## DIVISION OF RESOURCES & GEOSCIENCE ADVICE RESPONSE

**Project: Snapper Mine Northern Extension - Modification 7**  
**Stage: Review of Modification Report**  
**Development Application: MP06\_0168-Mod-7**

DIAGRAM MP06\_0168-MOD 7

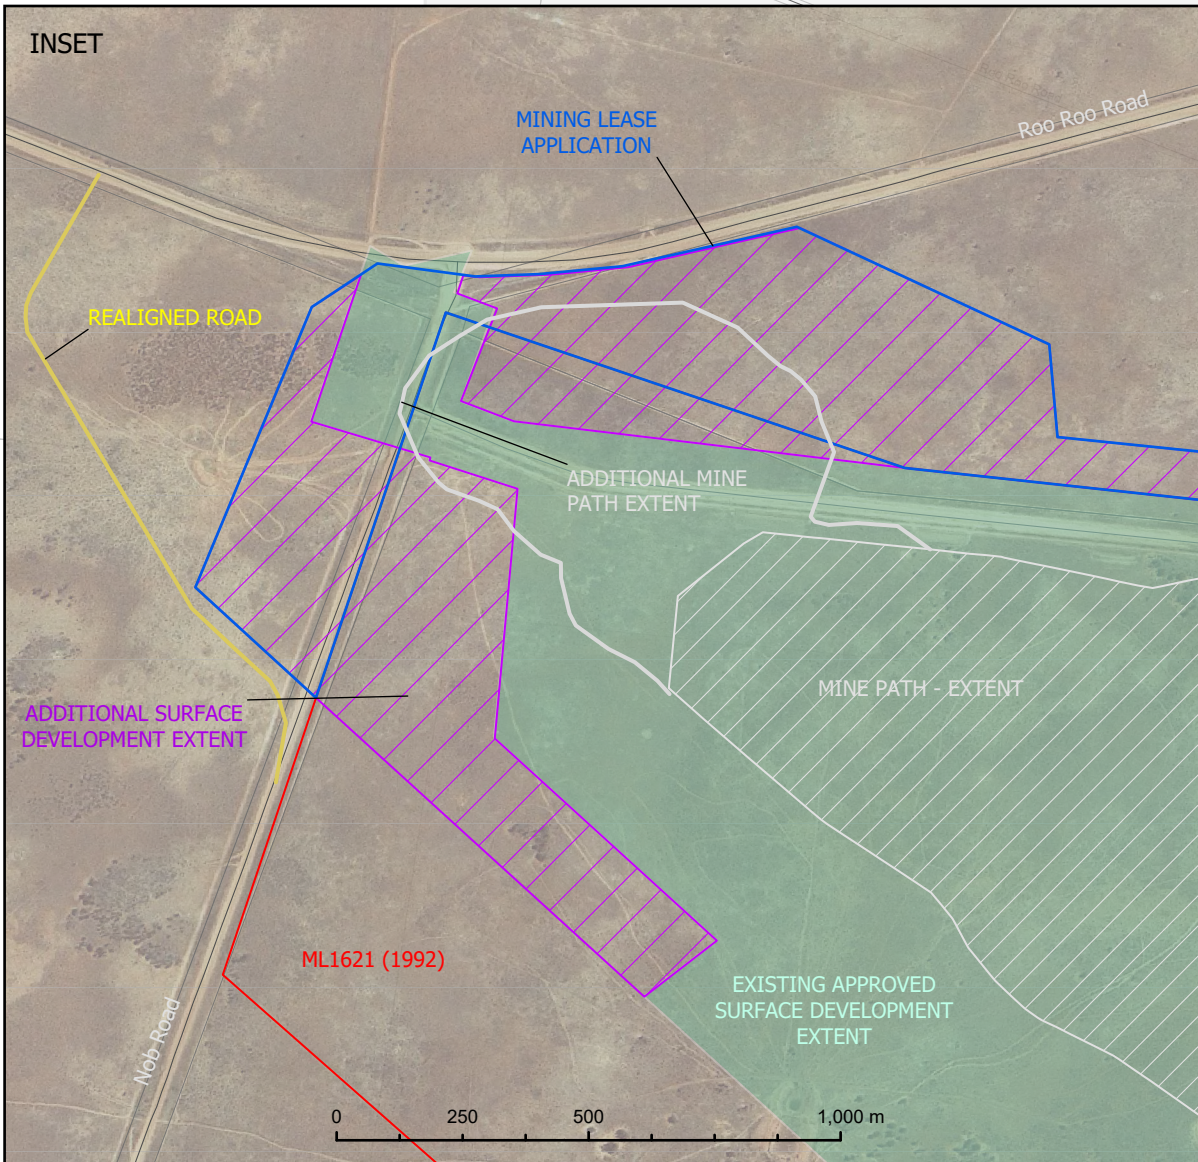
The Division notes that the project is located within existing Exploration Licence 8503 (Act 1992) and is adjacent to the existing operations area of Mining Lease 1621 (Act 1992) each held by the Proponent (see Attachment B).

As Ilmenite, Leucoxene, Rutile and Zircon are prescribed minerals under the *Mining Act 1992* the Proponent is required to apply for appropriate mining title(s) allowing for mineral extraction, such as a mining lease, from the Division to undertake mining. Tronox has advised the Division of their intention to lodge a mining lease application to cover the additional activities required by the Project identified as "additional surface development extent" within Attachment B.
